TOWN AND COUNTRY PLANNING ACT 1990 FULL

Reference: H08-0846-25 **Date of Decision:** 23rd October 2025
Applicant: Mr A Murfet
C/O 15 The Quays
Burton Waters
Lincoln
LN1 2XG
Location: Adj 3-4 Bowgate Gosberton Spalding
Description: Proposed dwelling

Figure 4- Proposed site layout

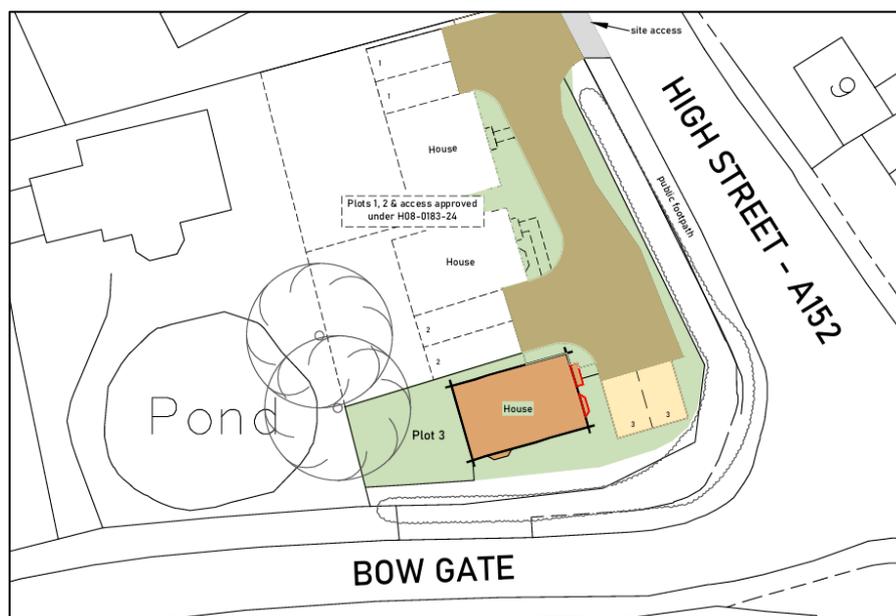
- 1 The proposed development represents an incongruous and cramped form of development due to the proposed scale and siting of the dwelling within the site. The proposal represents an overdevelopment of the site which would be out of keeping with the locality, character and appearance of the area. This would result in an unacceptable impact on the character and appearance of the area.
